CLAREMONT BUSINESS PARK 2 PRELIMINARY PLAN

PRELIMINARY PLAN

DATE	BY	DESCRIPTION
02.20.2020	B.I.	COUNTY COMMENTS
03.31.2020	B.I.	COUNTY COMMENTS
04.23.2020	B.I.	COUNTY COMMENTS
07.01.2020	B.I.	COUNTY COMMENTS
08.07.2020	B.I.	COUNTY COMMENTS

CLAREMONT BUSINESS PARK 2 PRELIMINARY PLAN

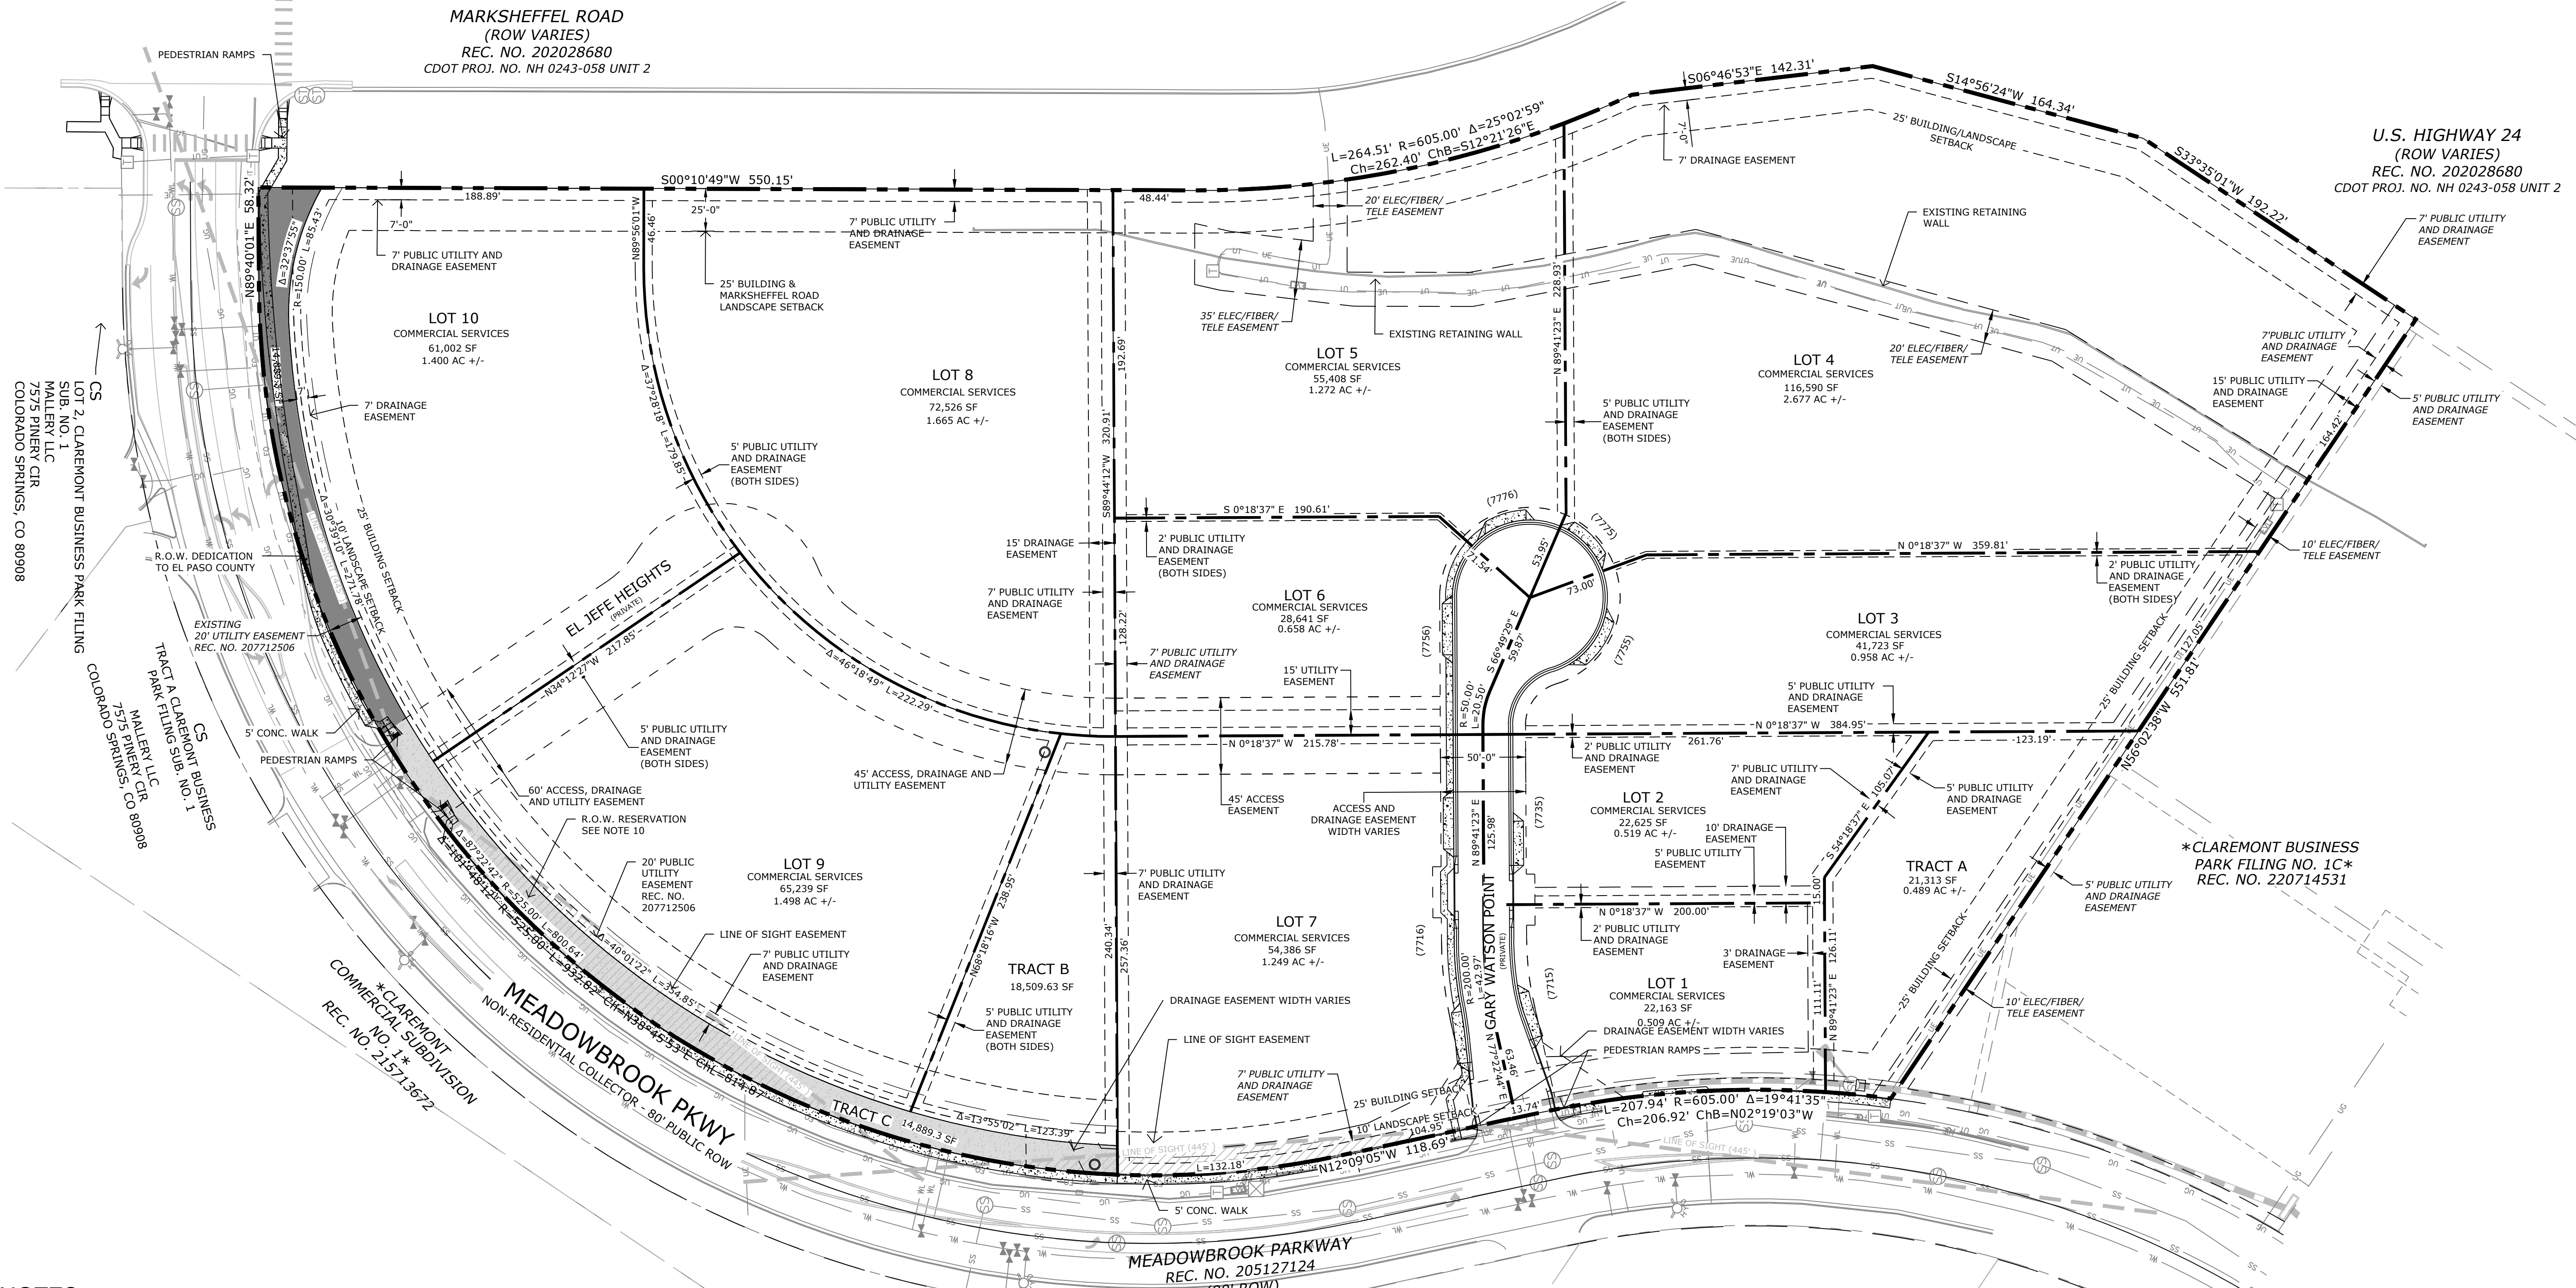
Please add a heading for waivers and list those requests as well.

Repeat Comment: The water resources report refers to Lots 1-7 as warehouse and Lots 8-10 as commercial. Please break that out in the site data table under the heading proposed use.
